**Narrabri Gas Project (SSD 6456)
Comment on the Environmental Impact Statement (EIS)**

Narrabri Gas Project (SSD 6456) Detailed comments – DPI Water Recommendations

Figure 3-1 Groundwater monitoring locations in the Gunnedah-Oxley Basin

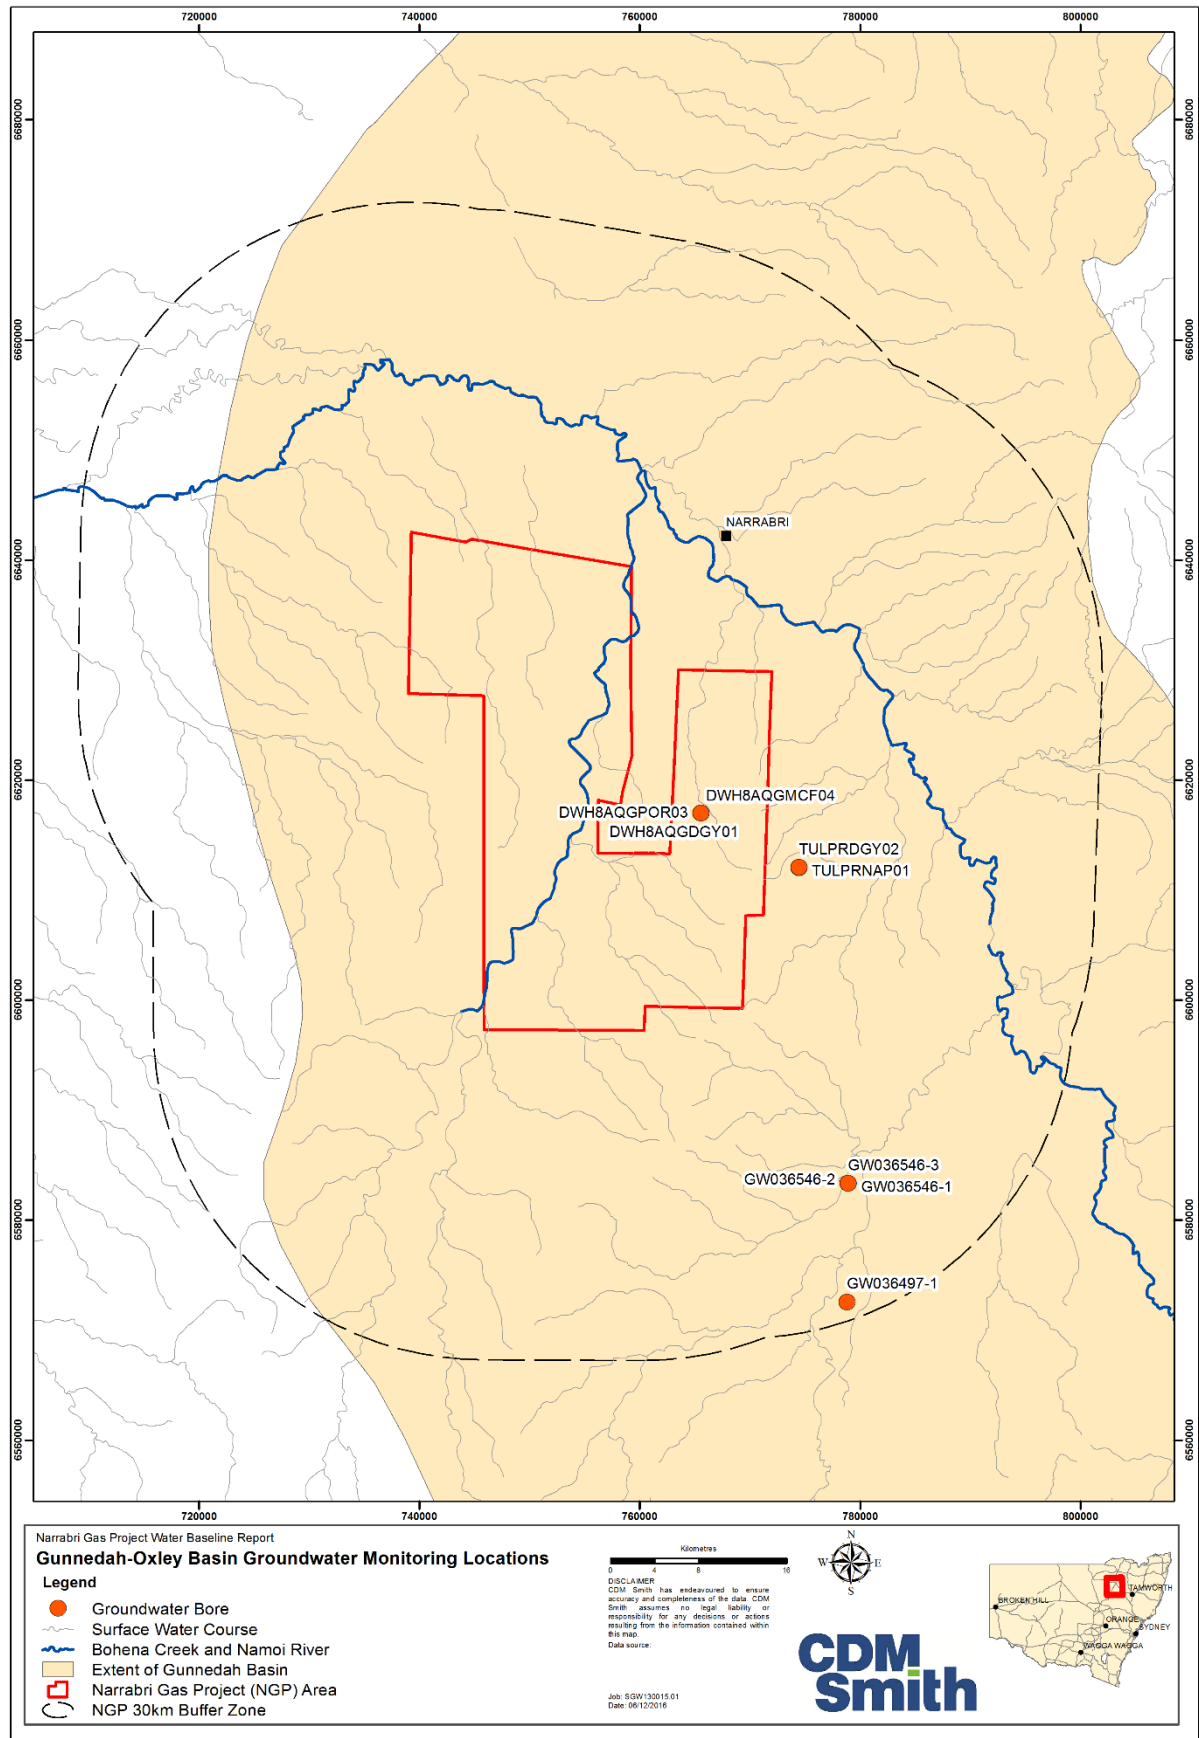
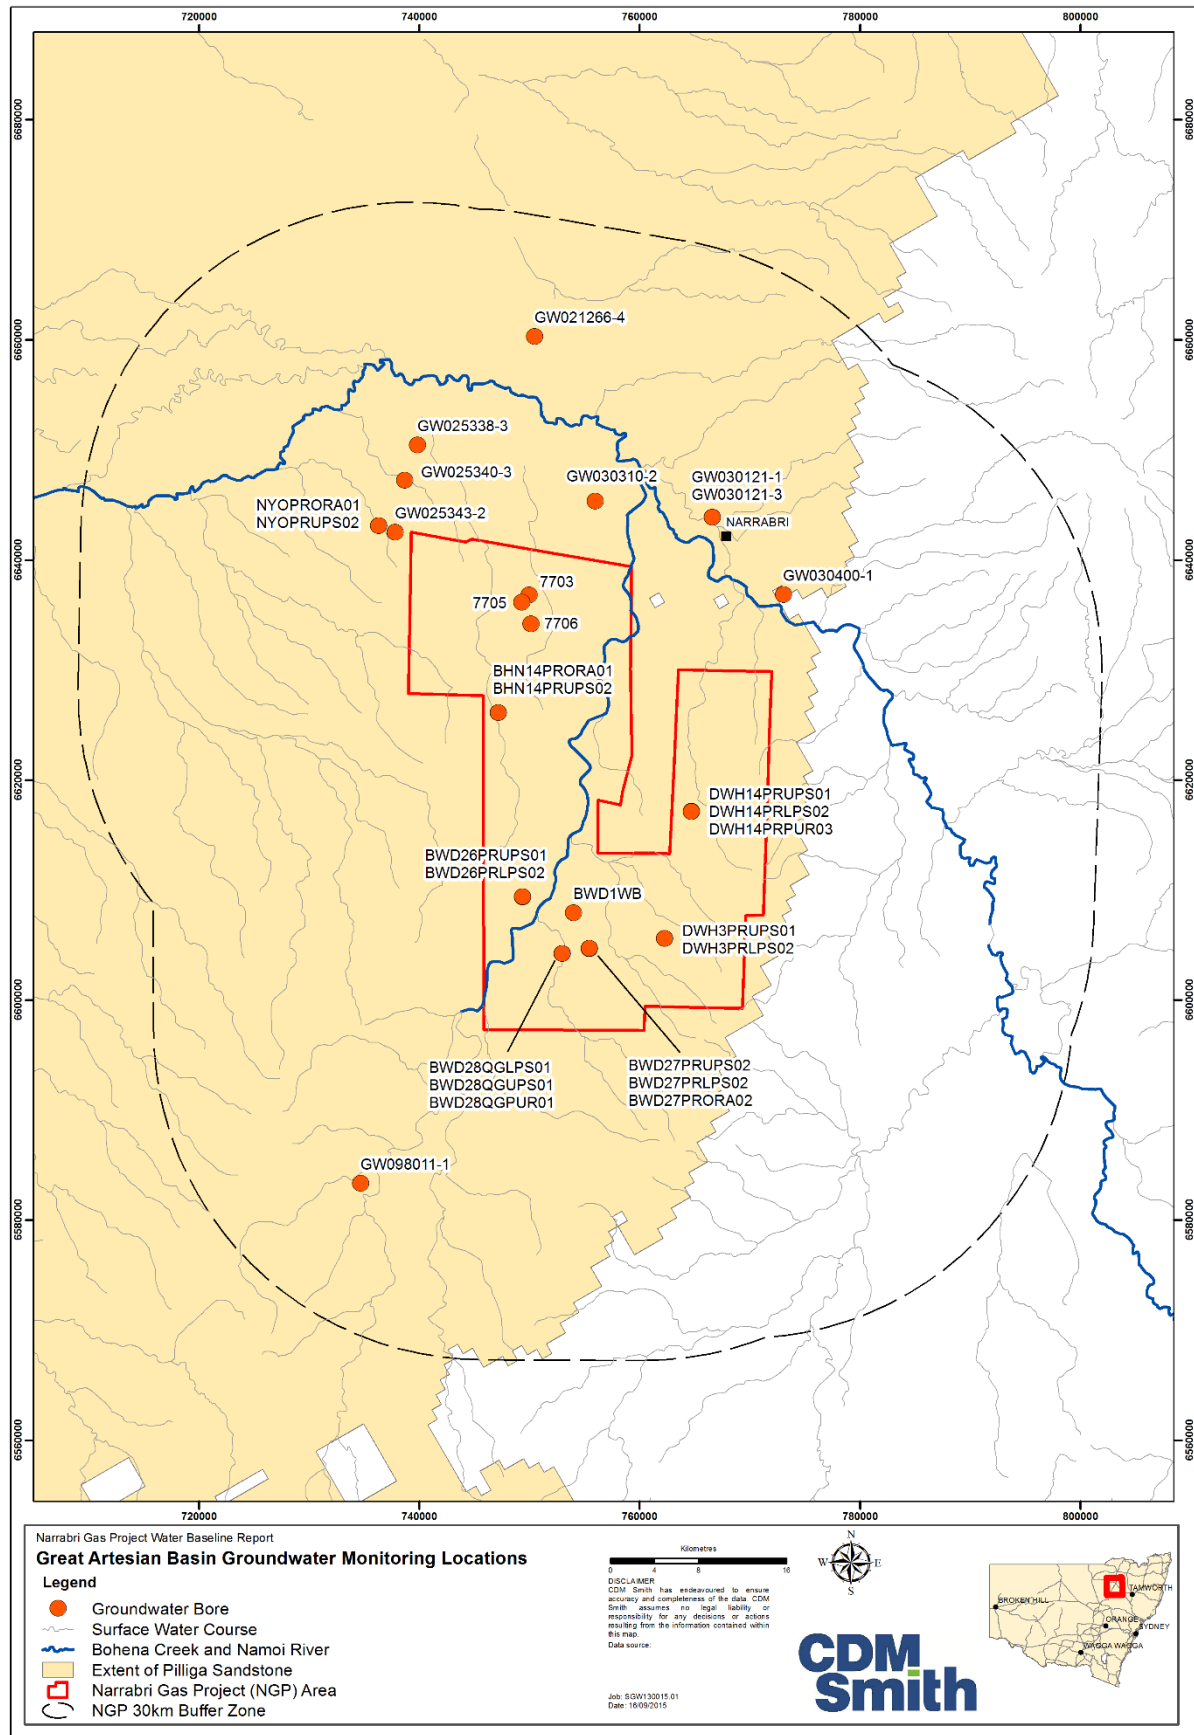
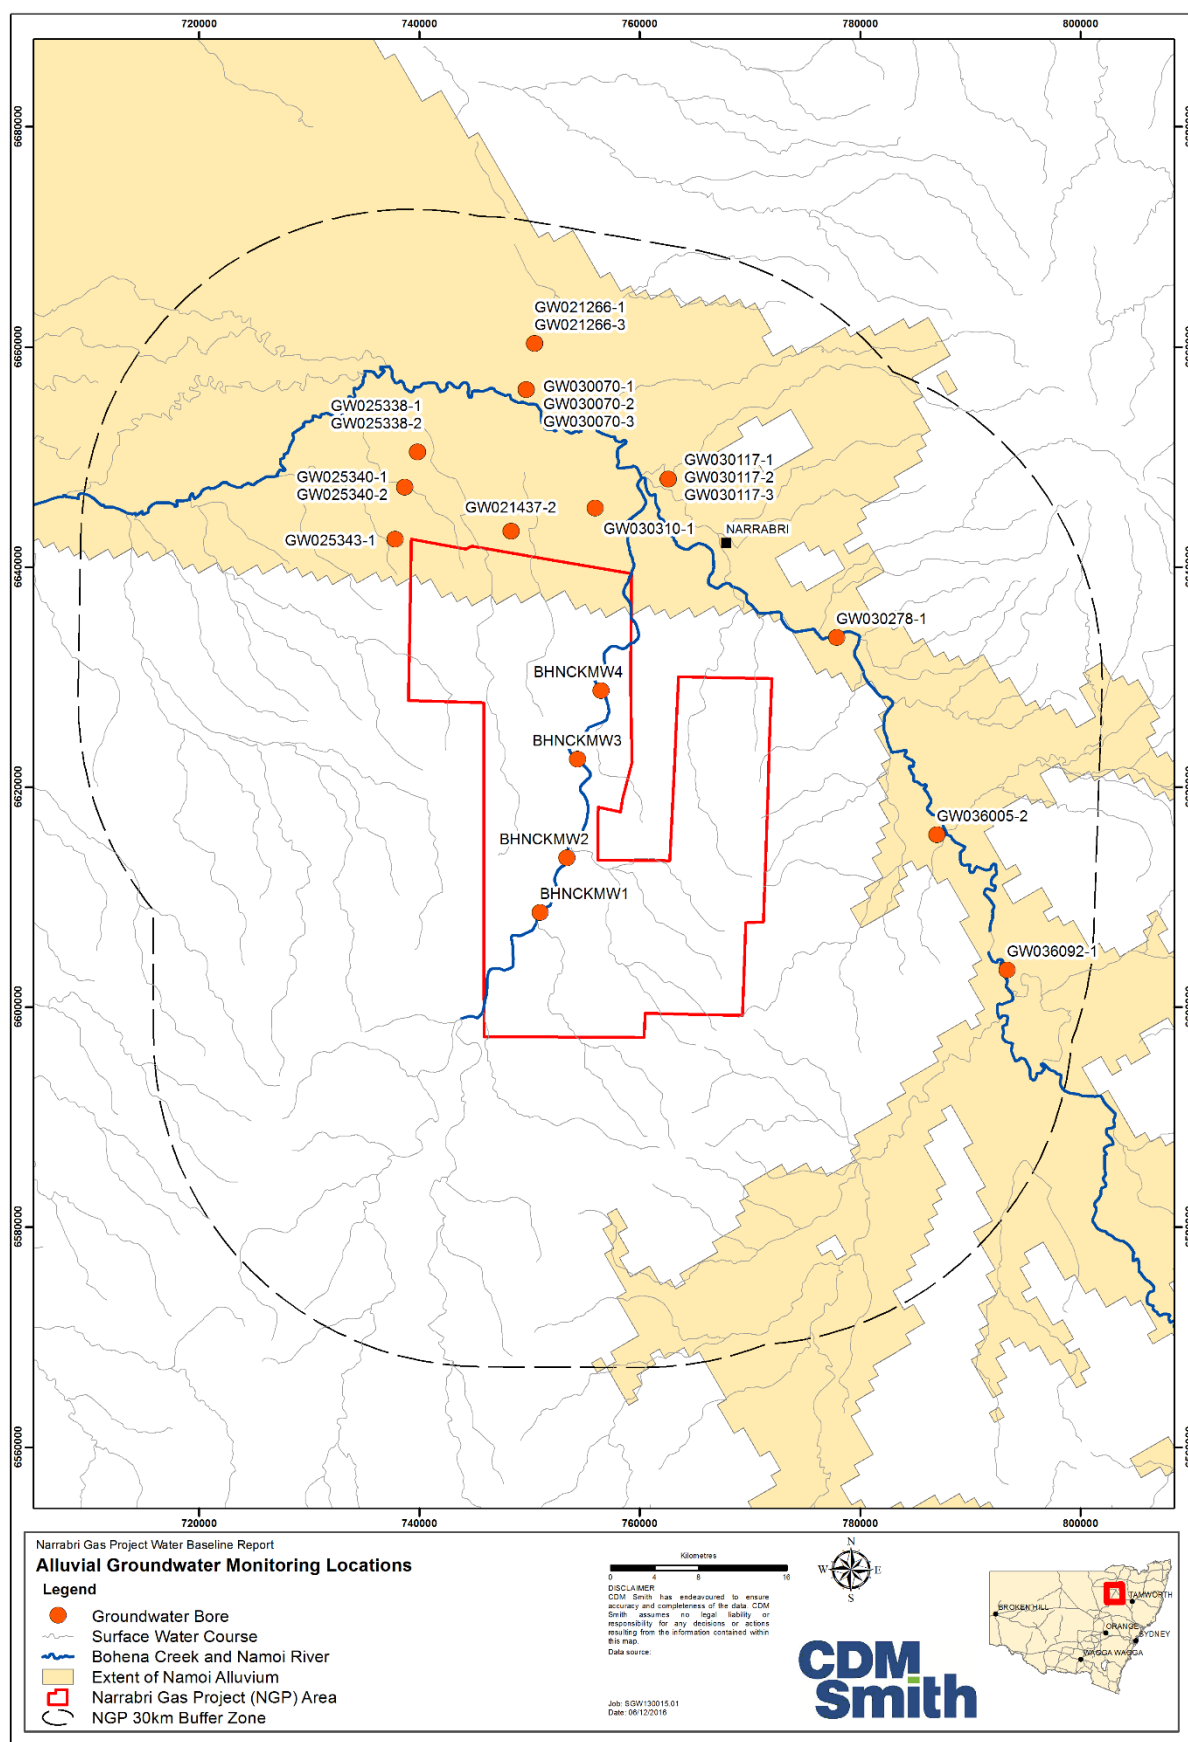
4. In Figures 3-1, 3-2 and 3-3 and Table 4-1 of the Water Baseline Report and Figures 3-4, 3-5, 3-6 and 3-9 and Table B-1 of the Water Monitoring Plan, DPIW has identified 12 government owned

monitoring bores that the proponent has assigned to a geological unit different to DPIW's interpretation (details are given in (Attachment D), the proponent is required to;

- a. justify the geological unit they have assigned to each of the twelve monitoring bores to the satisfaction of DPIW or
- b. amend the relevant sections to include each bore in the geological unit assigned by DPIW, this will result in changes to the assessment of baseline condition that must be addressed by the proponent.

Figure 3-4 Locations of private landholder bores

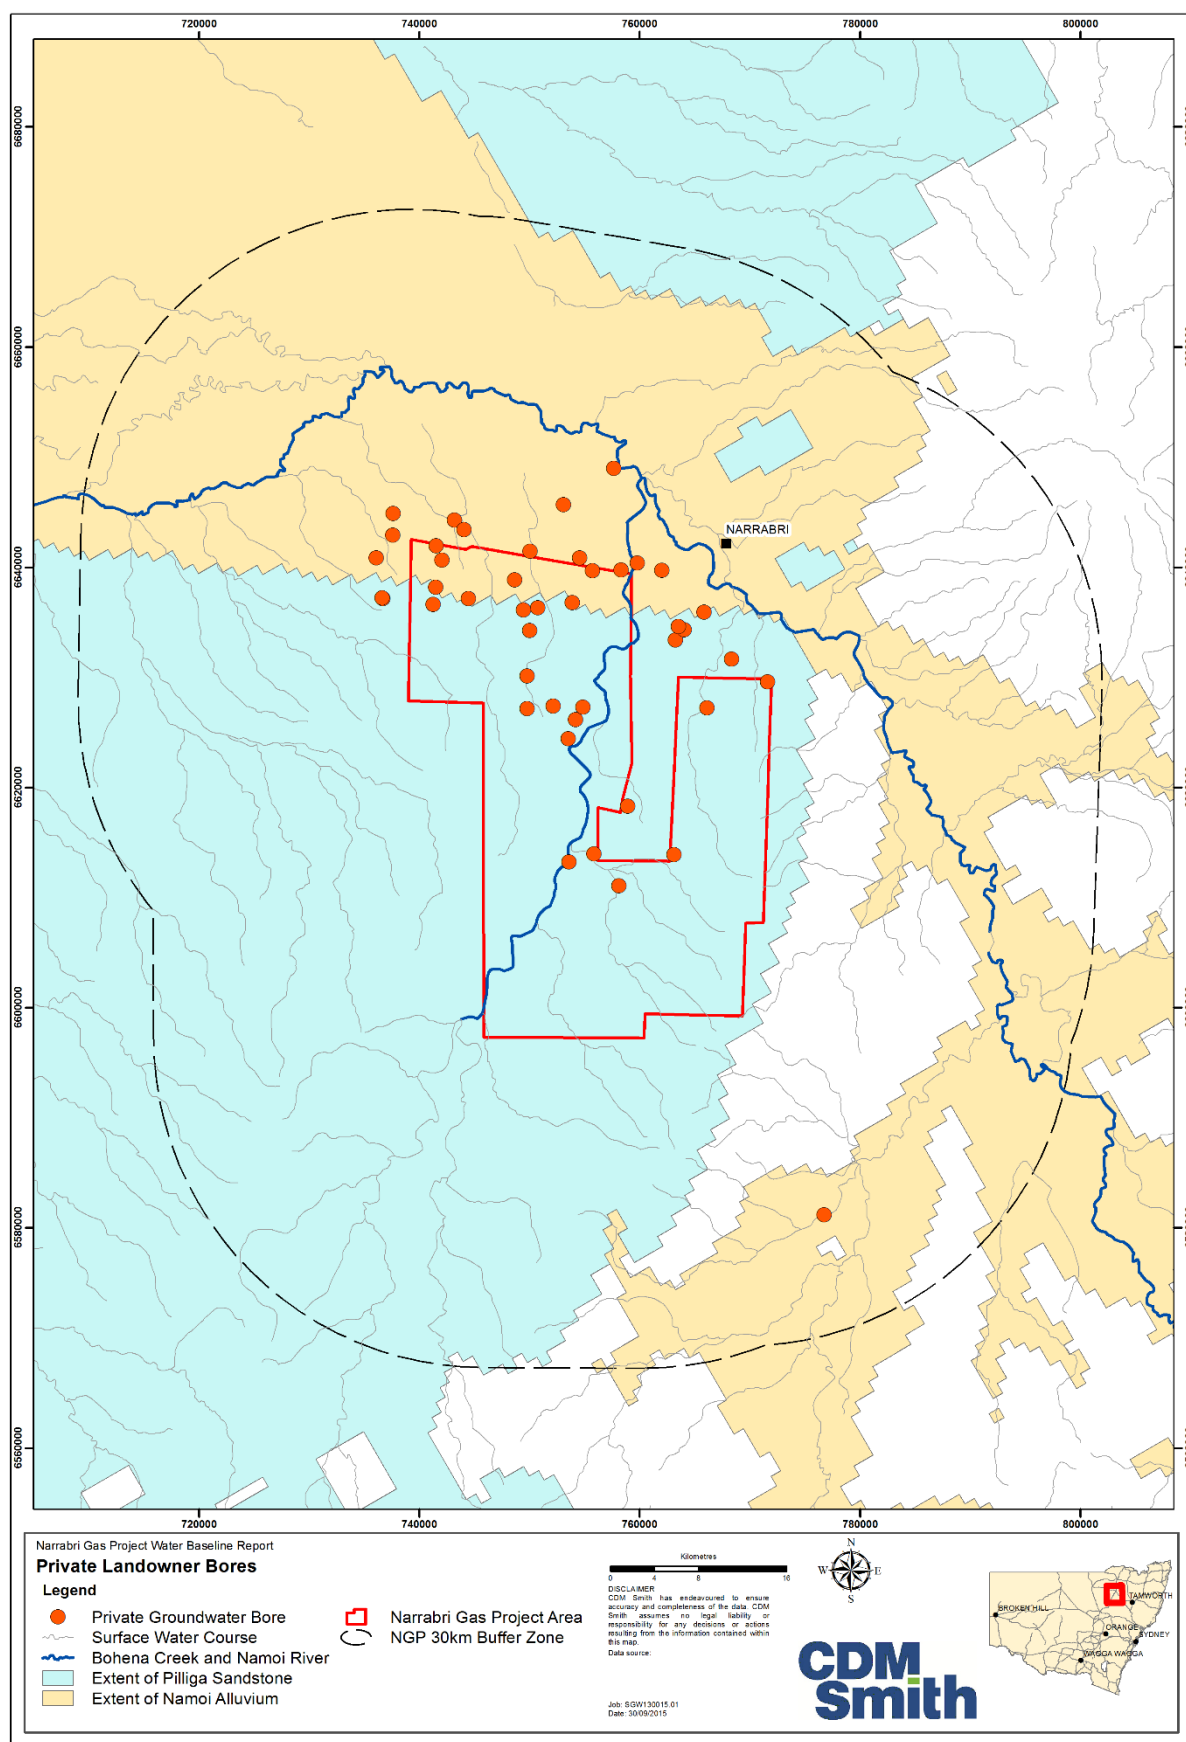
- d. Provide further information on the existing landowner bores shown in Figure 3-4 including; bore location information, type of data collected, and frequency of collection.
